CITY OF ALBUQUERQUE

January 24, 2022

**RE: The Peaks by Markana
Grading & Drainage Plans
Engineer's Stamp Date: 01/05/22
Hydrology File: C18D088**

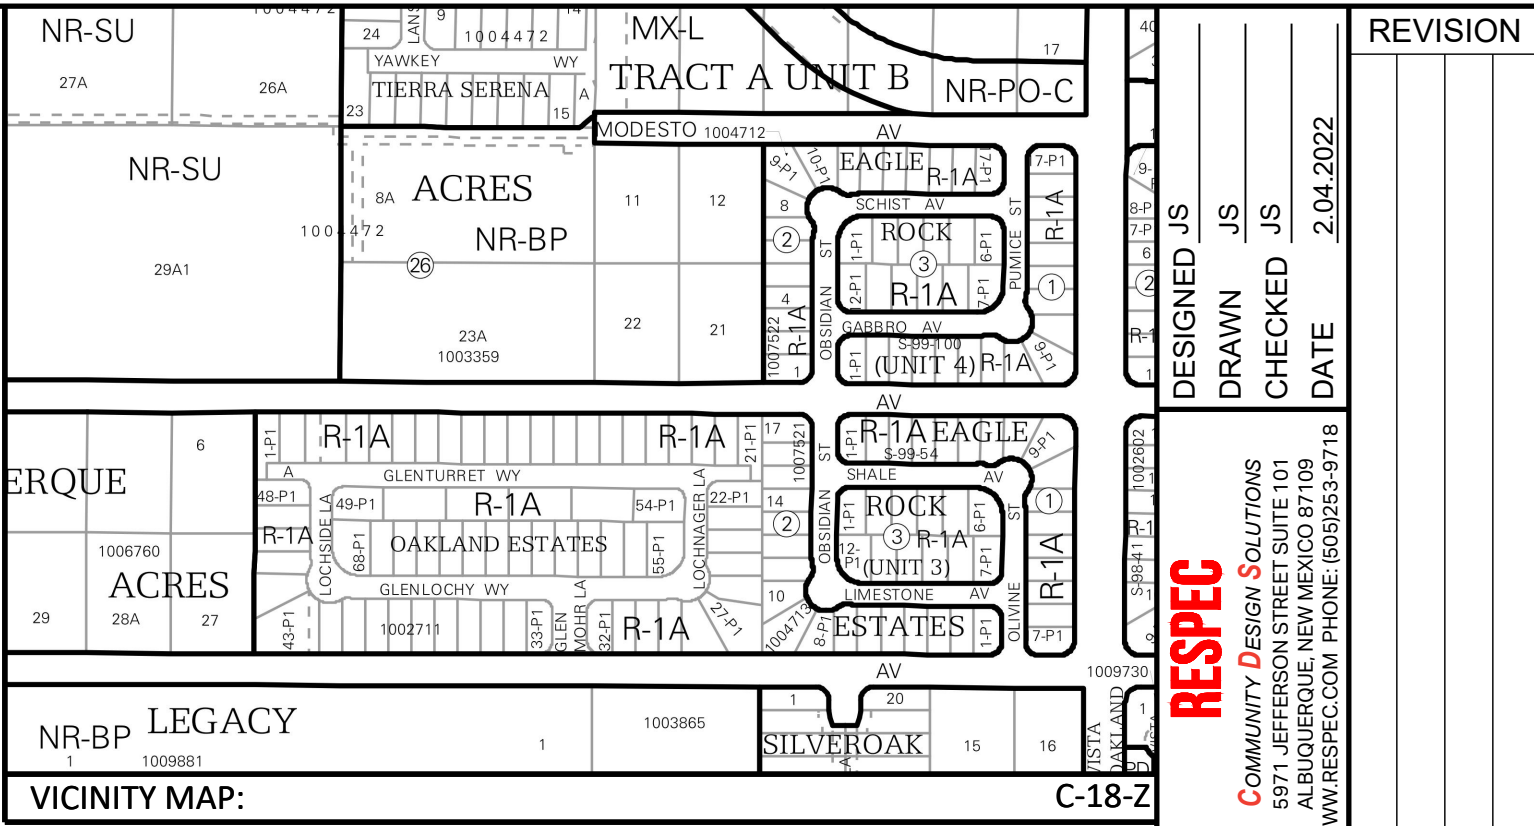
6. Sheet C101. Per the DPM, the following must be on the Grading Plan.
 - a. Please provide a Vicinity Map.
 - b. Please provide the Benchmark information (location, description and elevation) for the survey contour information provided.
 - c. Please provide the FIRM Map and flood plain note with effective date.
 - d. Please provide a legal Description of the property.
7. Sheet C100. Please show and calculate the amount of stormwater quality pond volume that was able to provide. Please use the attached Waiver form for the remainder of the volume.
